Recommendation Report for Planning Permission for Works or Extension to a Dwelling

REF NO: R/142/20/HH

LOCATION: 61 Worthing Road
Rustington
BN16 3JU

PROPOSAL: Dropped kerb for off road parking at front of property.

★ Crossover
Area

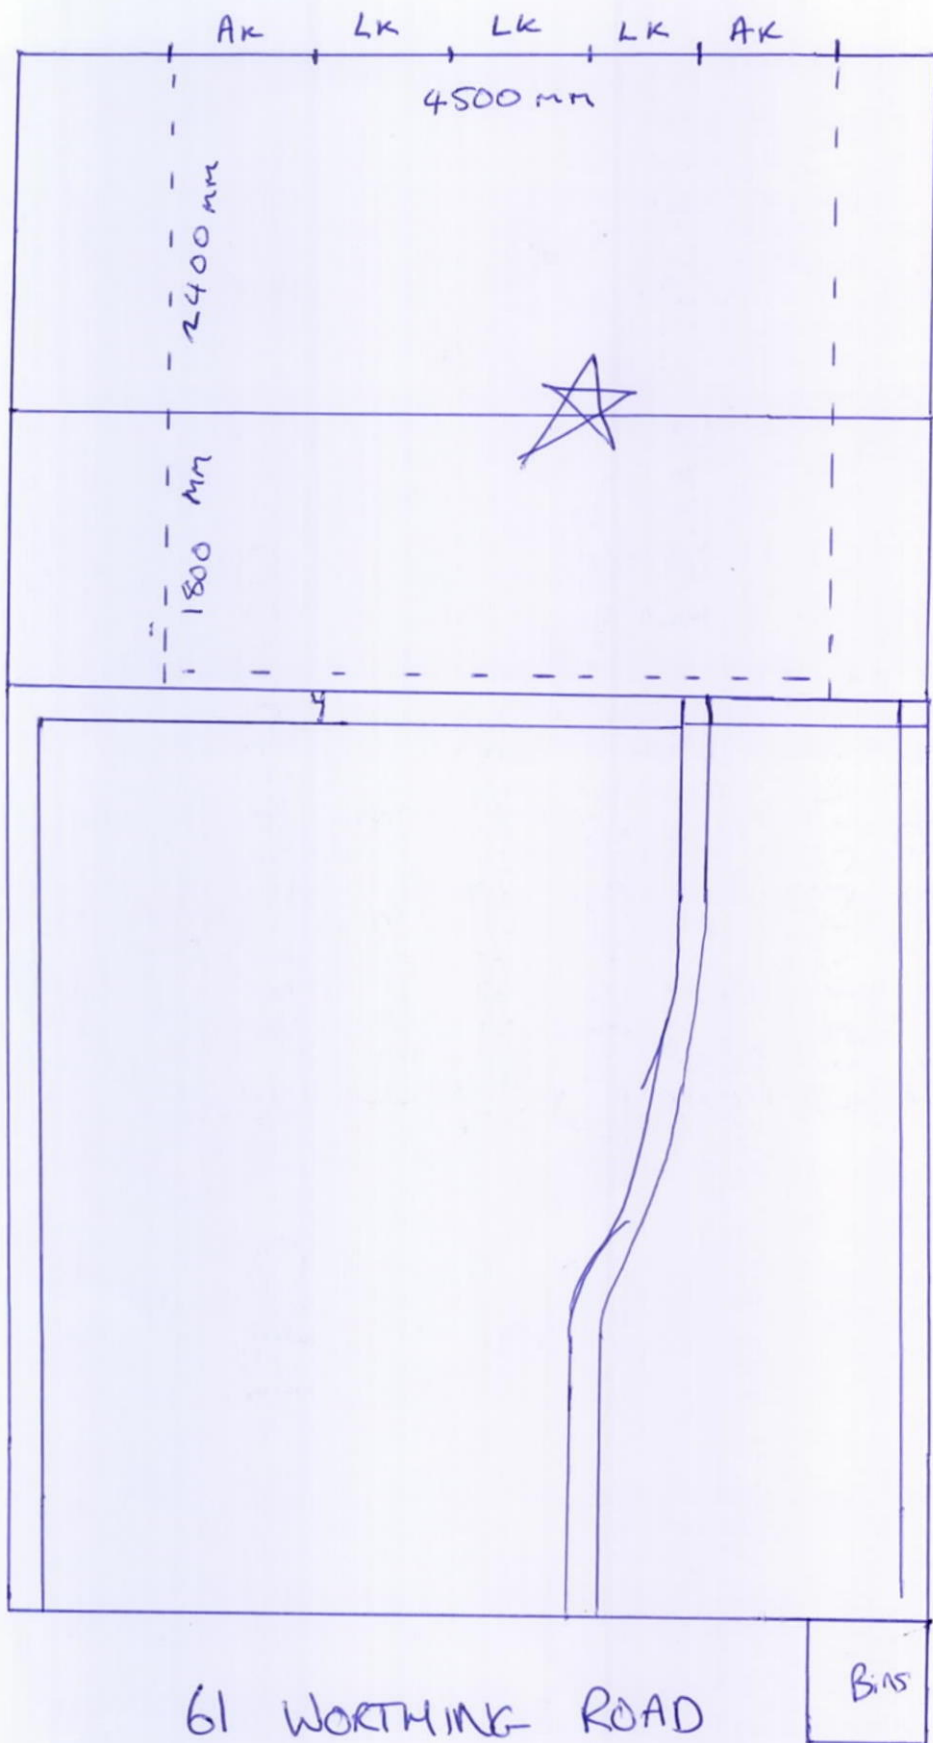
The Local Highway Authority would prefer for the design of the driveway to be altered to ensure that vehicles do not overhang the footway.

Comments noted. It would seem the LHA have misinterpreted the plans, as the plan shows a parking area of which is considered acceptable for the parking of a car.
